To: Charlotte Planning, Design & Development

From: Doug Lozner

Date of Review: September 27, 2021

Rezoning Petition #: 21-127

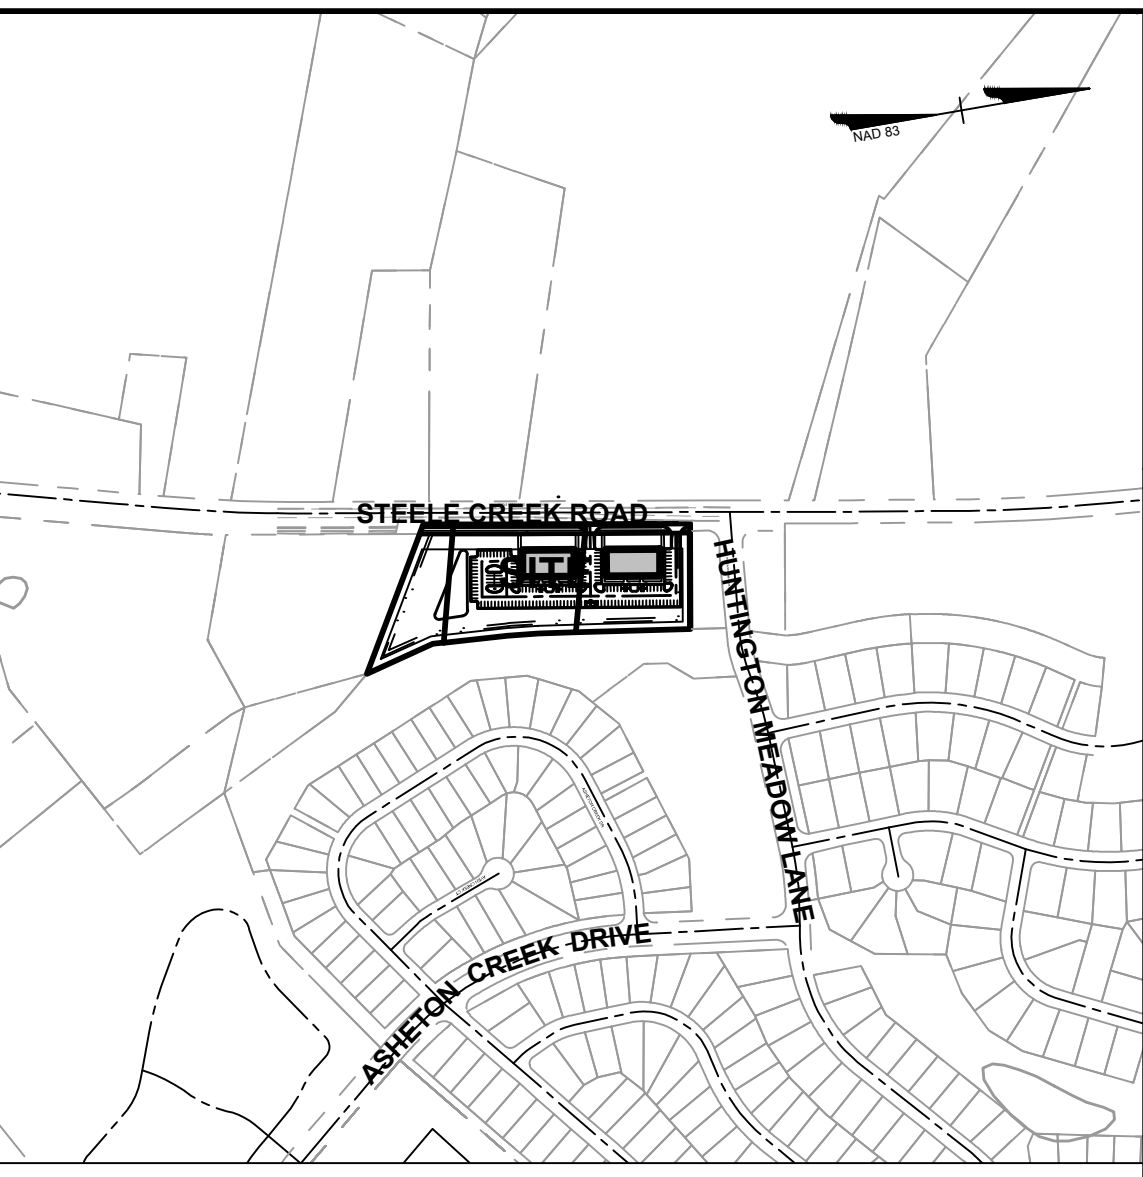
Concerning Storm Water: The proposed rezoning plan sheet indicates a proposed location for storm water management. Please include the following notes on the plan sheet under "Environmental Features": *The location, size, and type of storm water management systems depicted on the Rezoning Plan are subject to review and approval as part of the full development plan submittal and are not implicitly approved with this rezoning. Adjustments may be necessary in order to accommodate actual storm water treatment requirements and natural site discharge points.*
